October 14, 2014

Subject: Fraker Roulston Boundary Line Adjustment (BL-14-00020)

EXHIBIT
 BOUNDARY LINE ADJUSTMENT
 KITTITAS CO. TAX PARCEL NUMBERS 555035 & 565035

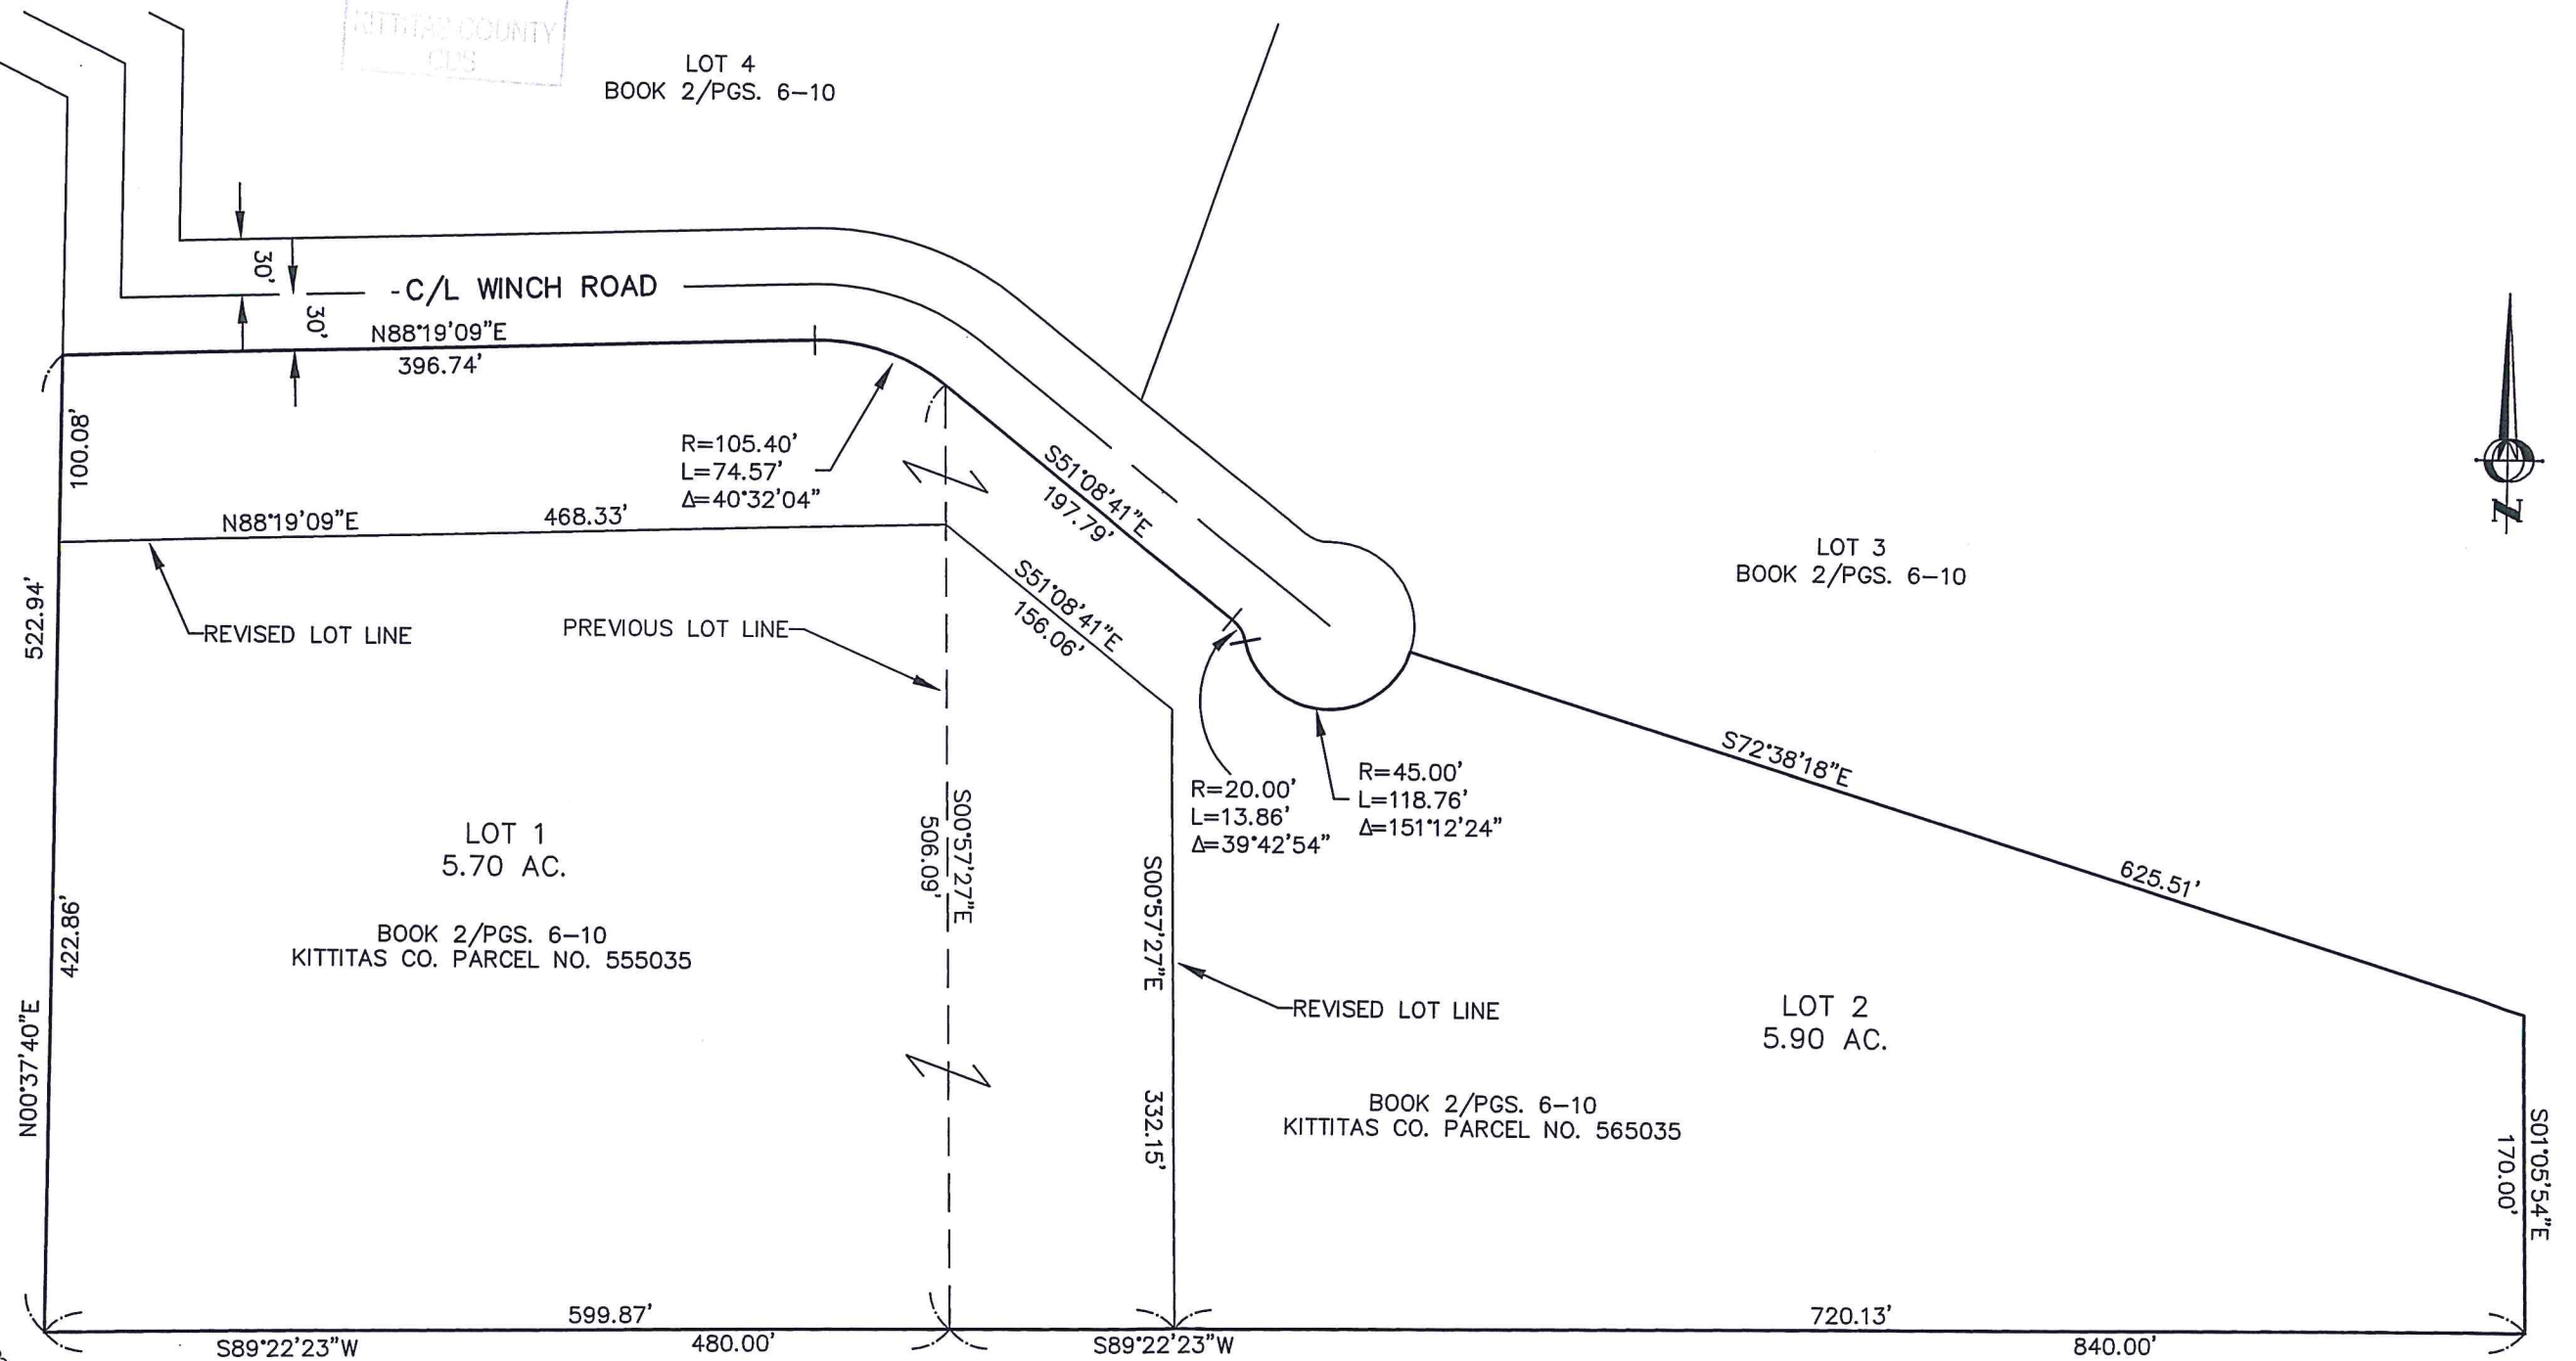
- *Location of Septic, Wells and all buildings on all parcels associated with Boundary Line Adjustment on a proposed and existing site plan.*
- *Project Narrative.*
